DEVELOPMENT REVIEW BOARD
TRANSPORTATION DEVELOPMENT

DRB Project Number: 1010675
Shops @ PDN

SUBJECT: Amended Site Plan for Subdivision

DATE: April 4, 2018

SDP-1.1

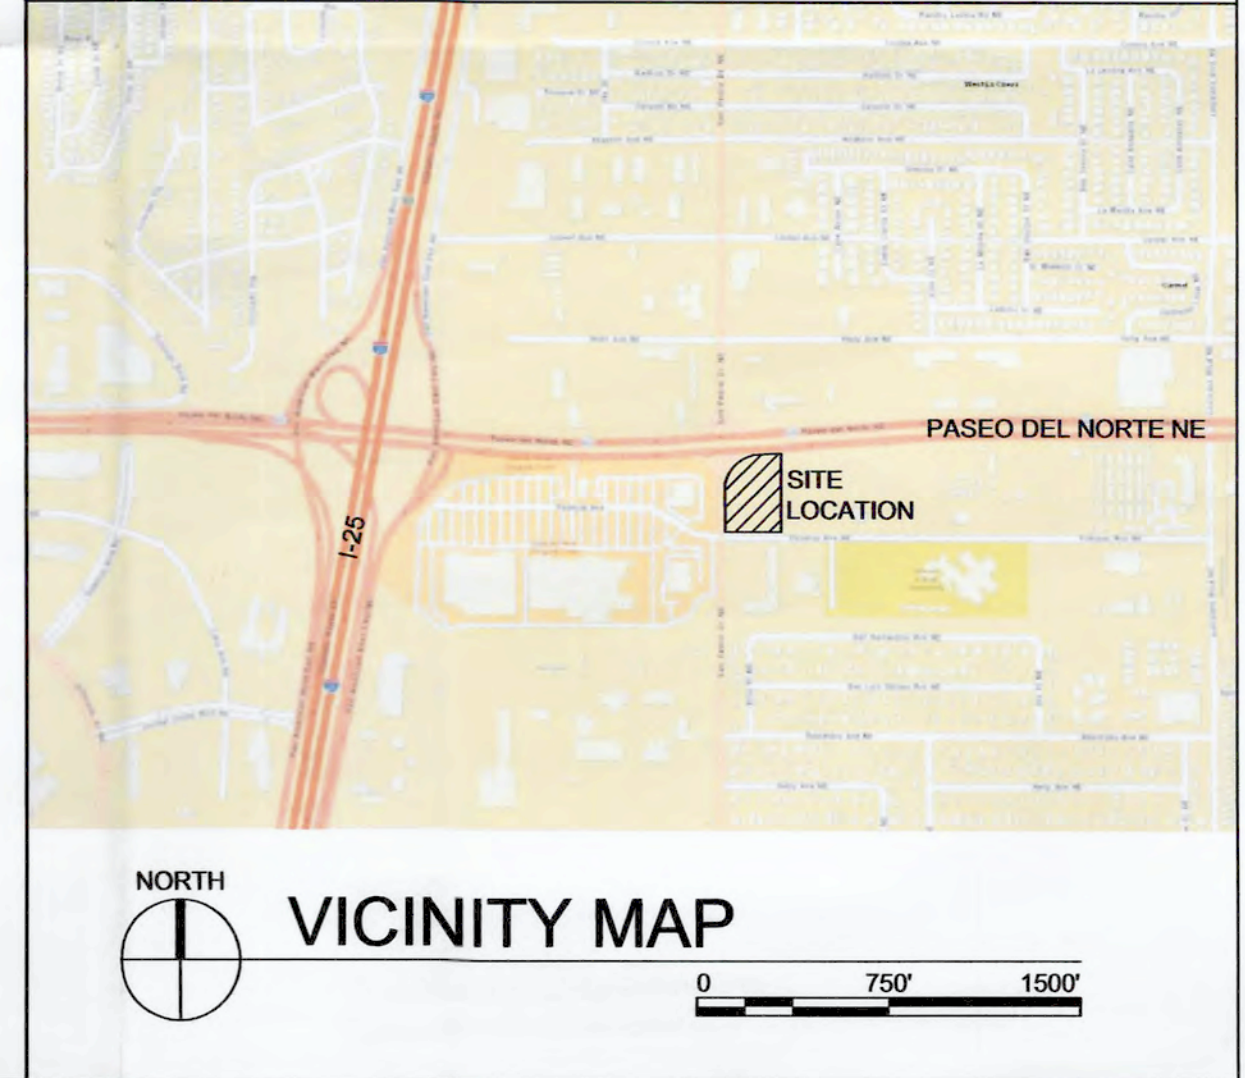
1. There appears to be a sign and large box in the NW corner of the site. Please label and provide an easement if necessary.
2. Show all vehicular and pedestrian access to the site.
3. Provide an updated infrastructure list.
